City of Portland, Maine - Building or Use Permit Application

Location of Construction: 273 Presumpscot St	Owner Name: C & N Properties Llc	Owner Address: Po Box 1838	Phone:
Business Name: Haskell & Hall	Contractor Name: RDB Construction, Inc	Contractor Address: 155 Center Street Auburn	Phone: 2077836339
Lessee/Buyer's Name	Phone:	Permit Type: Additions - Commercial	Zone: I-M

RE: Review Comments for Final Plan – Administrative Review

Project Name: 273 Presumpscot Street; Addition of Second Story Office Space
Project ID: 10-79900036
Project Address: 273 Presumpscot St **CBL:** 420 - B-005-001
Planner: Shukria Wiar

A-2.1

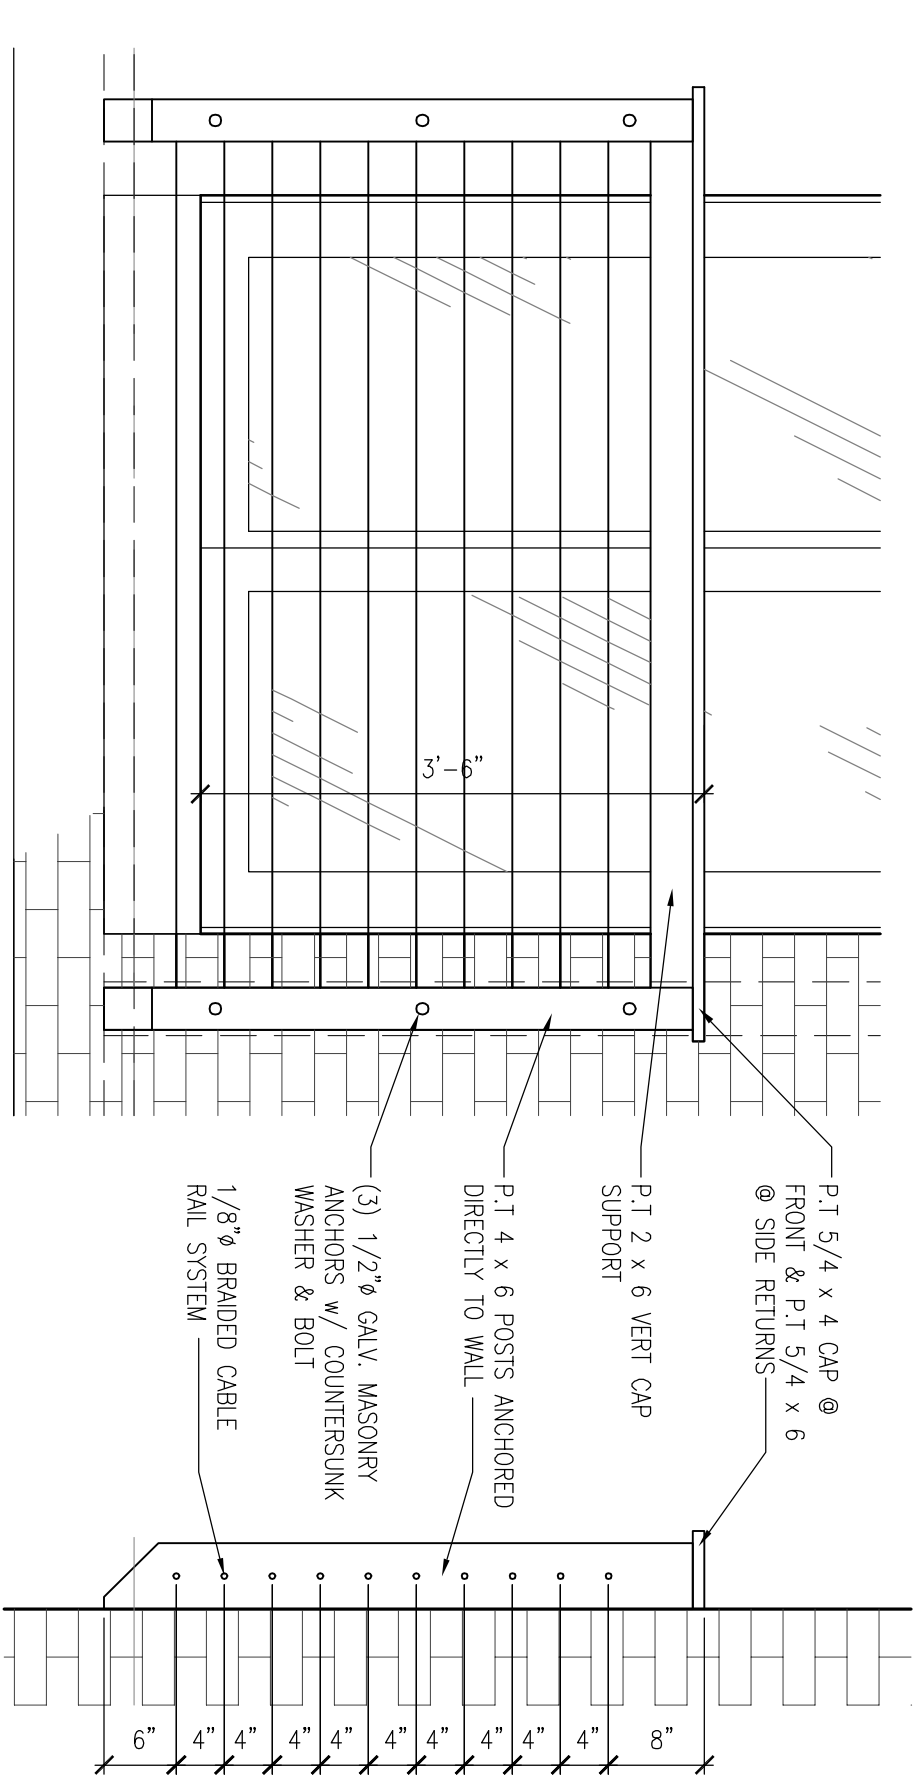
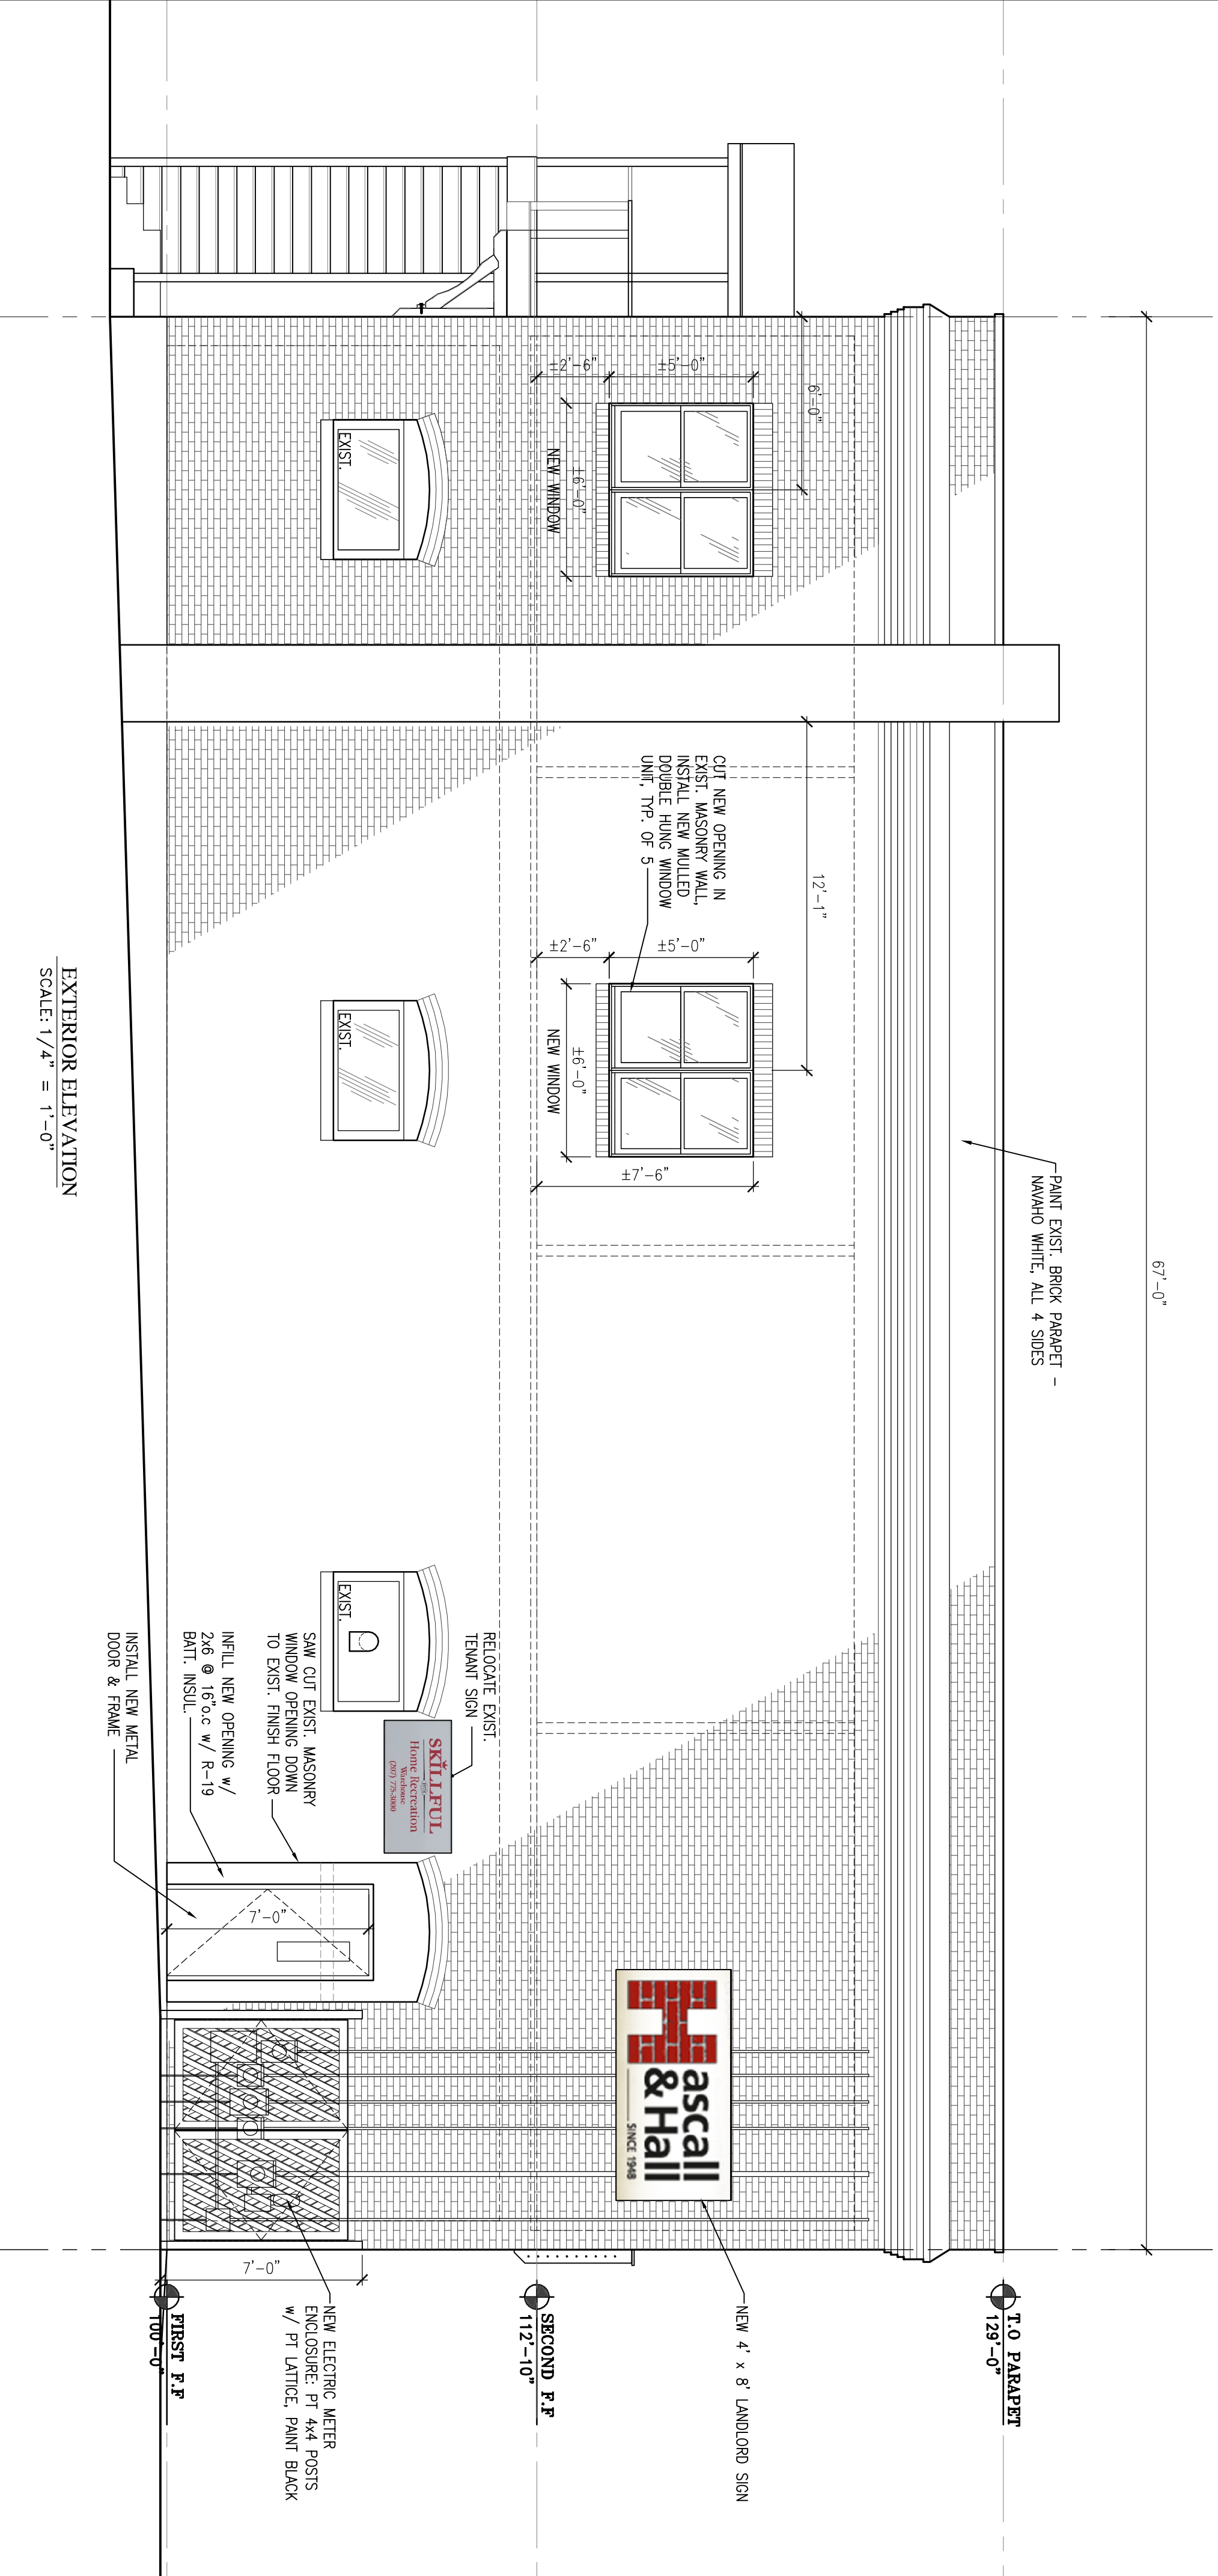
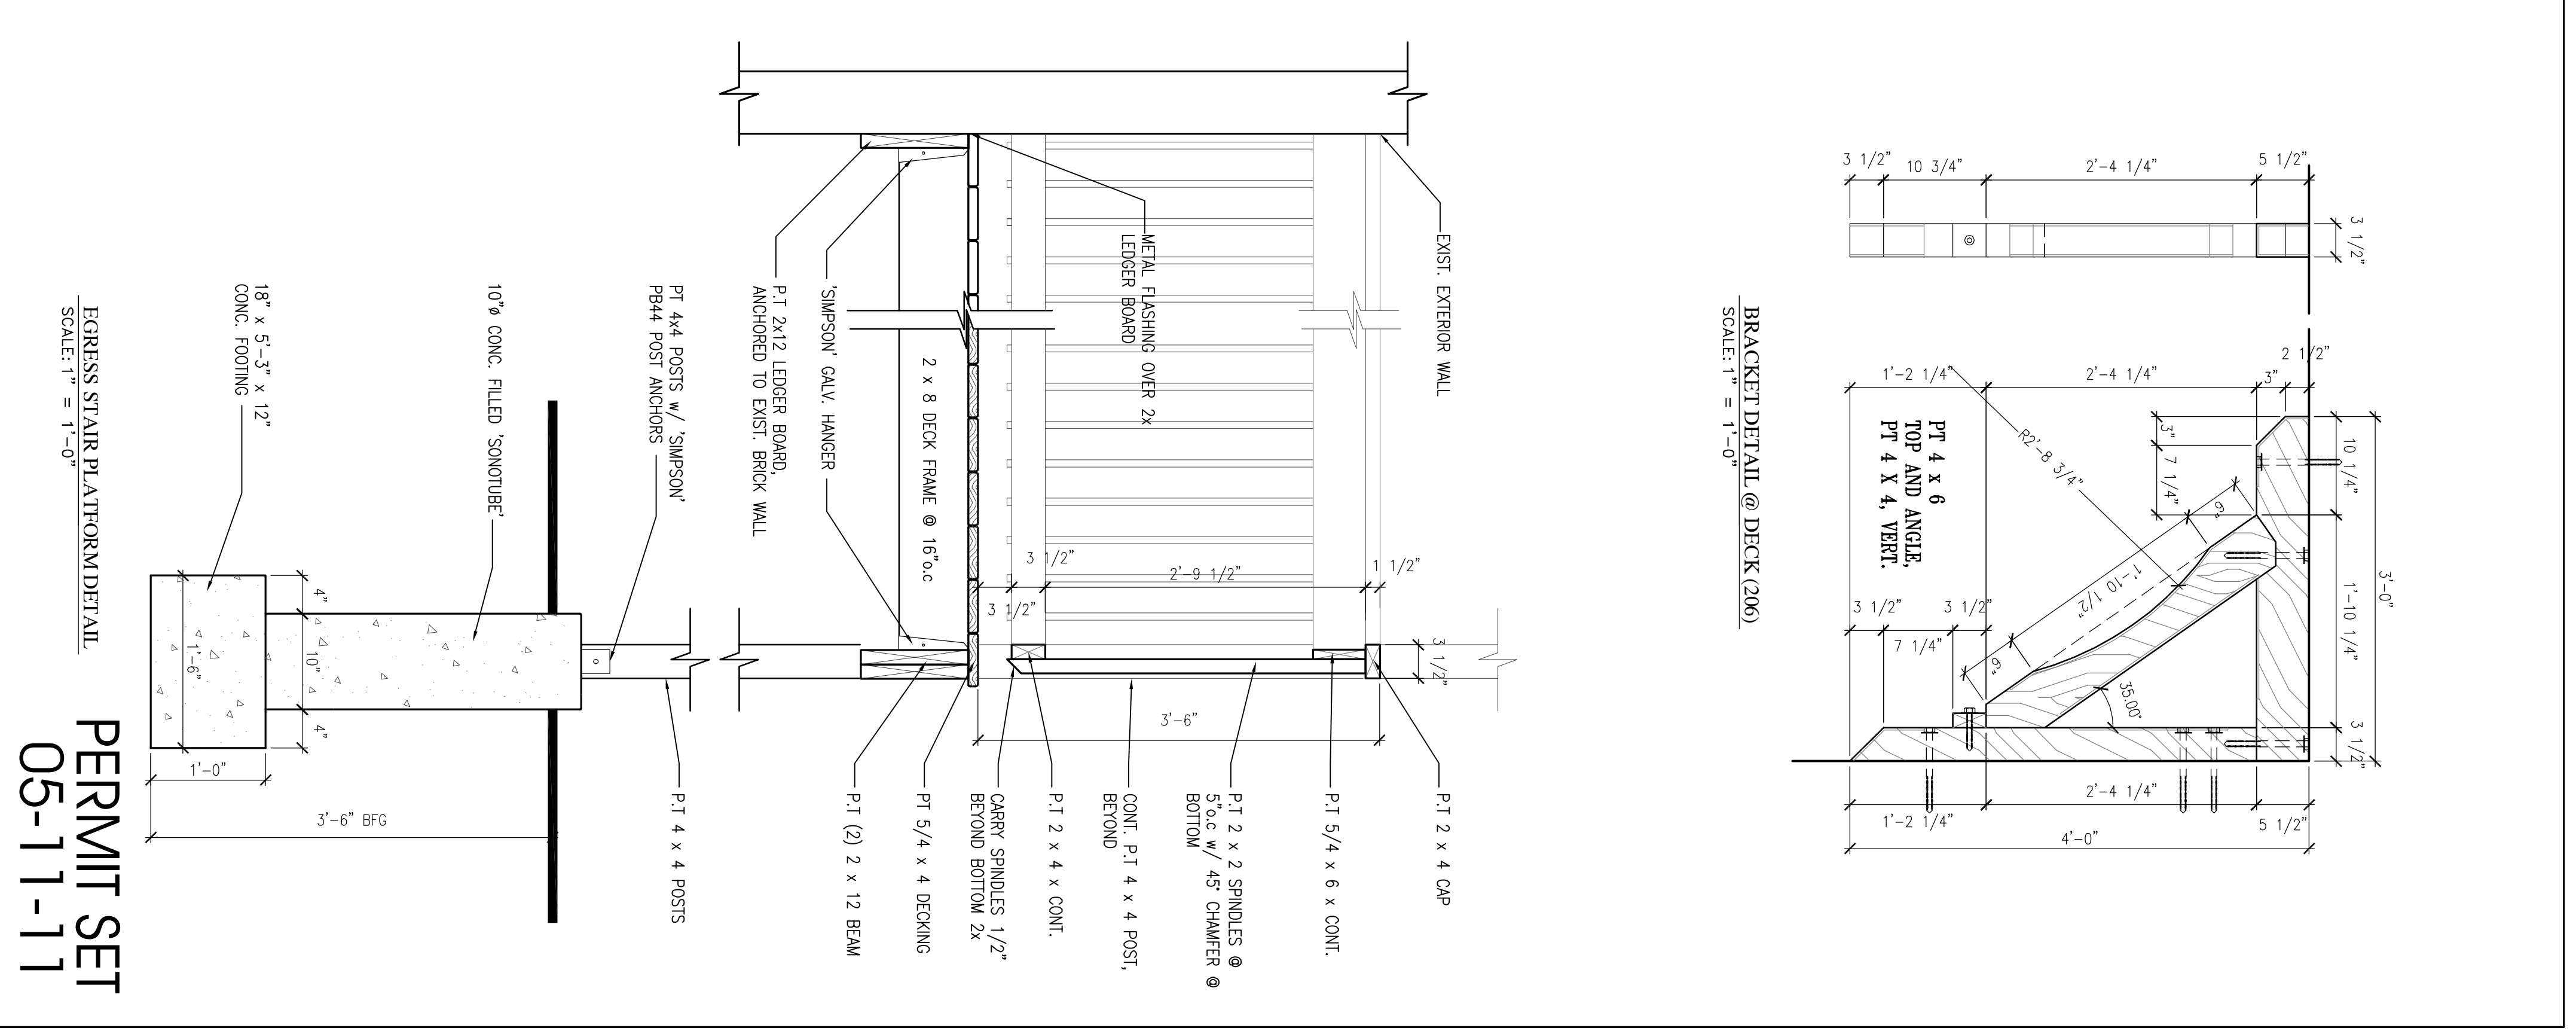
The application does not show an elevation of the existing building and addition. I cannot complete my review without such a building elevation.

The application does not show an elevation of the existing building and addition. I cannot complete my review without such a building elevation.

The building elevation sketch is being shown having a height of 29.17 feet where 45 feet is the maximum allowed. The project is currently meeting the building height requirements.

11/17/10 - sketch showing addition
OK
